Subject: RE: Noise reduction scheme

Reference: planning application 11 Wheelwrights Close Arundel

GENERAL ARRANGEMENT
DRAWING

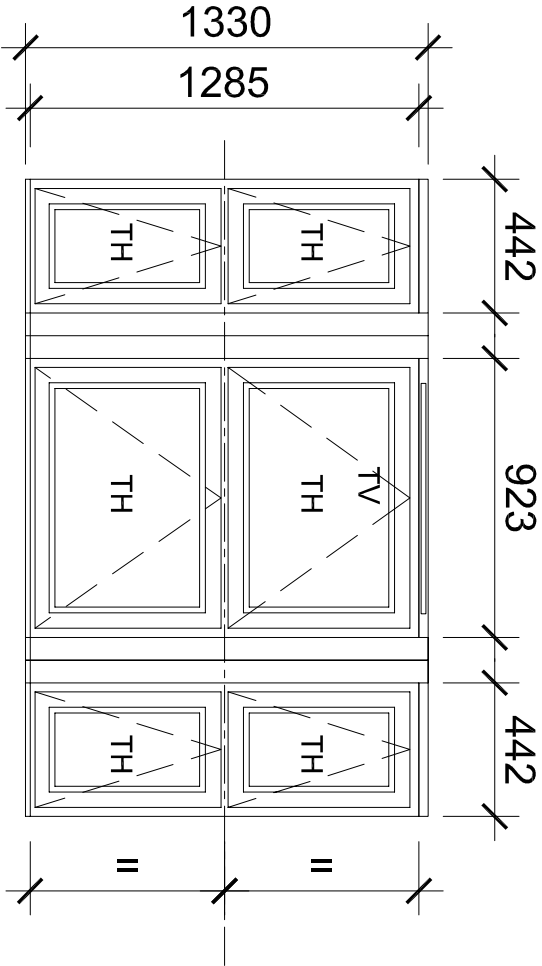
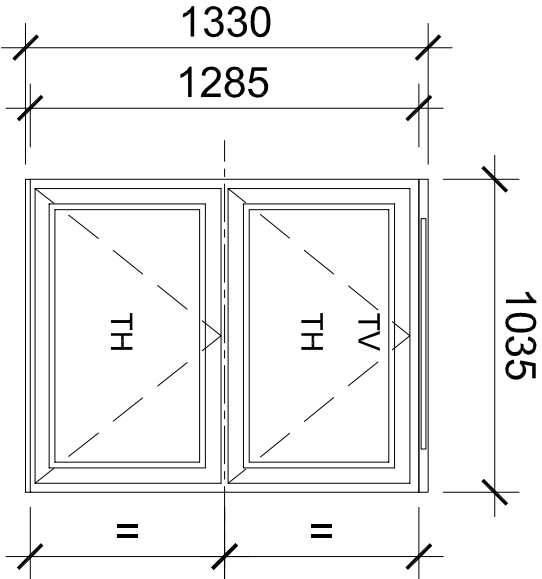
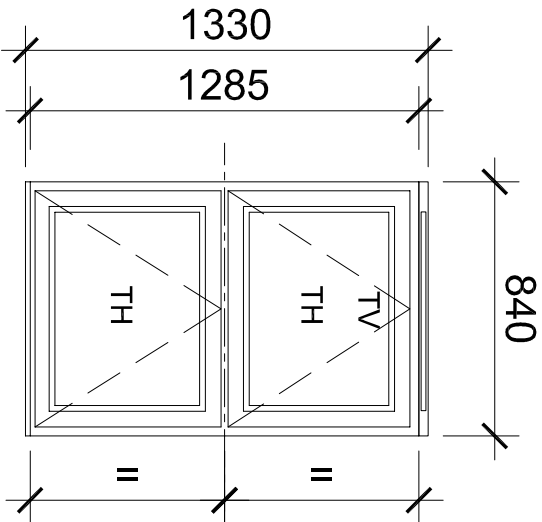
Whilst it is positive that both designs are timber, it is unfortunate that they are still not sliding sash windows. Any revised application submitted should clarify why this is not possible.

Option one would definitely be out of character with only the lower half of the window opening utilising a top hung mechanism, whereas option 2 the whole window is 'top hung' and would 'open' and also not fully appropriate. However I suggest option 2 could be supported on the basis that it would only appear out of keeping when open and this is likely to be limited given the need for the window design revision is to reduce external noise levels.
